Pearl Place 2

184 Pearl Street, Portland, Maine

Addendum No. 2 to Contract Documents

August 17, 2011

E1.2

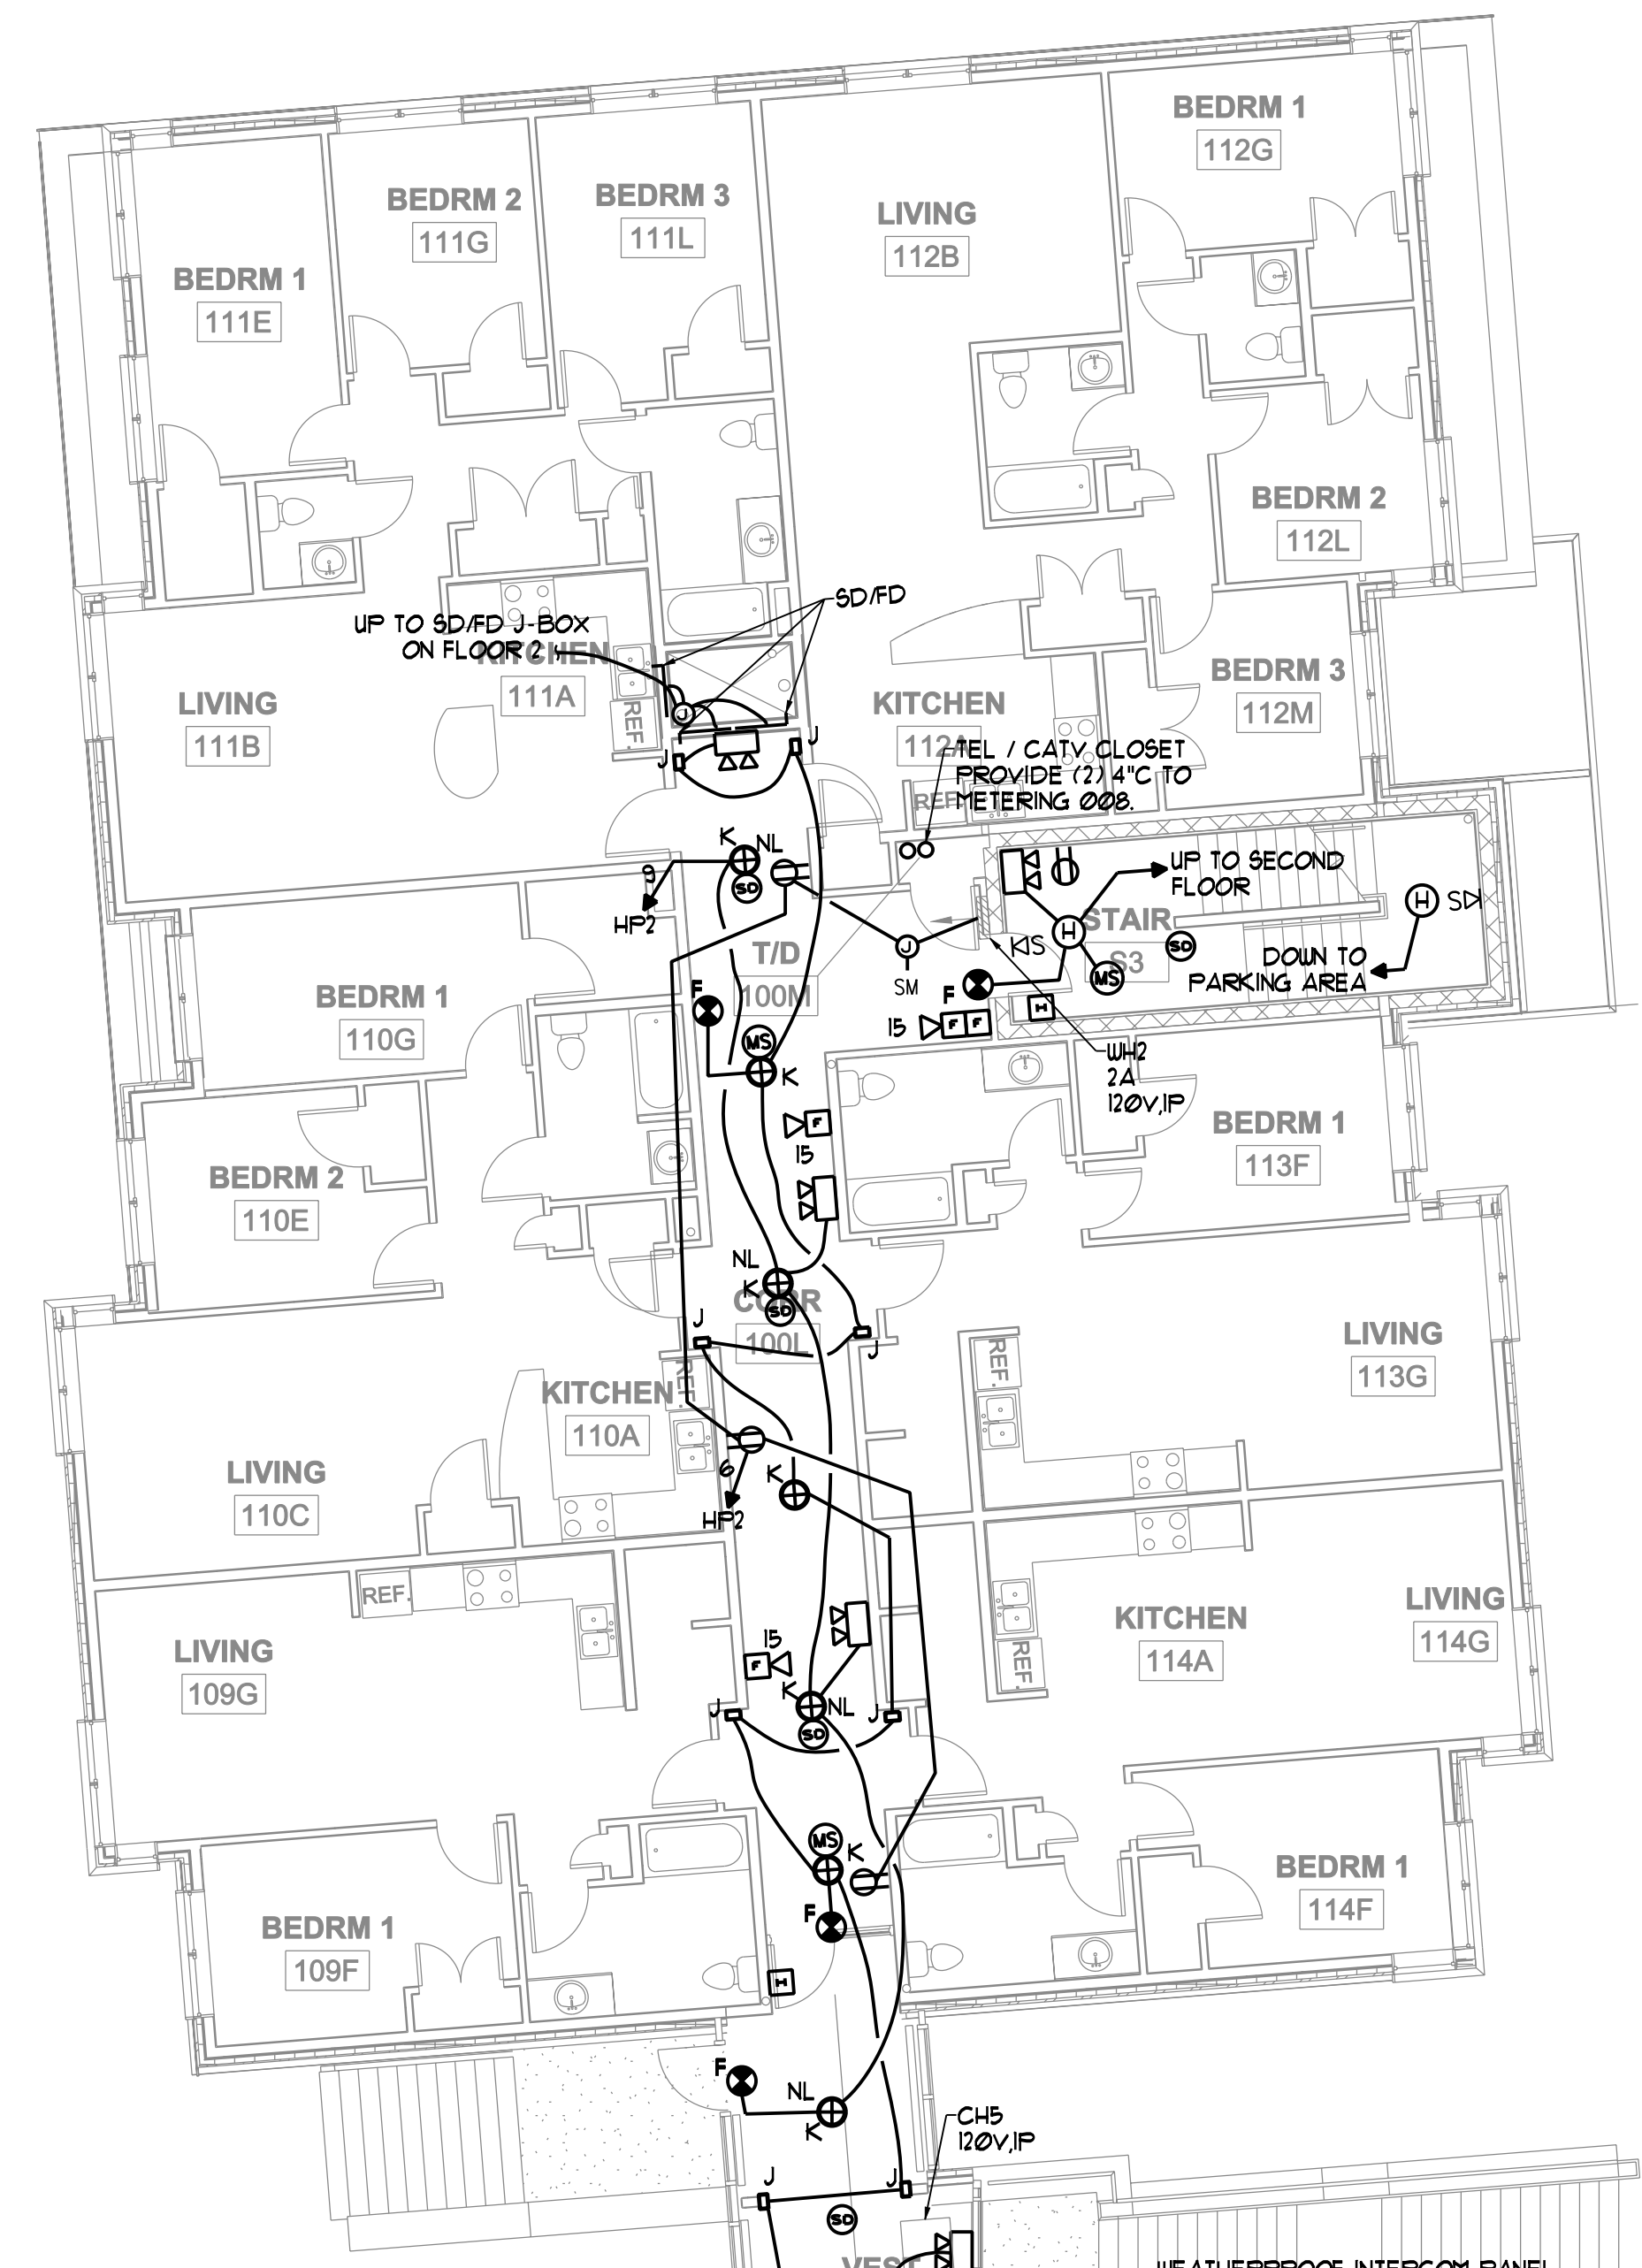
- E.** Drawing E1.2: All fire alarm horn/strobes in corridors shall be 15 Cd.
- F.** Drawing E2.1: ADD: General Note 1 – “All General and Unit Fire Alarm Notes on sheet E2.2 shall apply to this sheet (E2.1)”
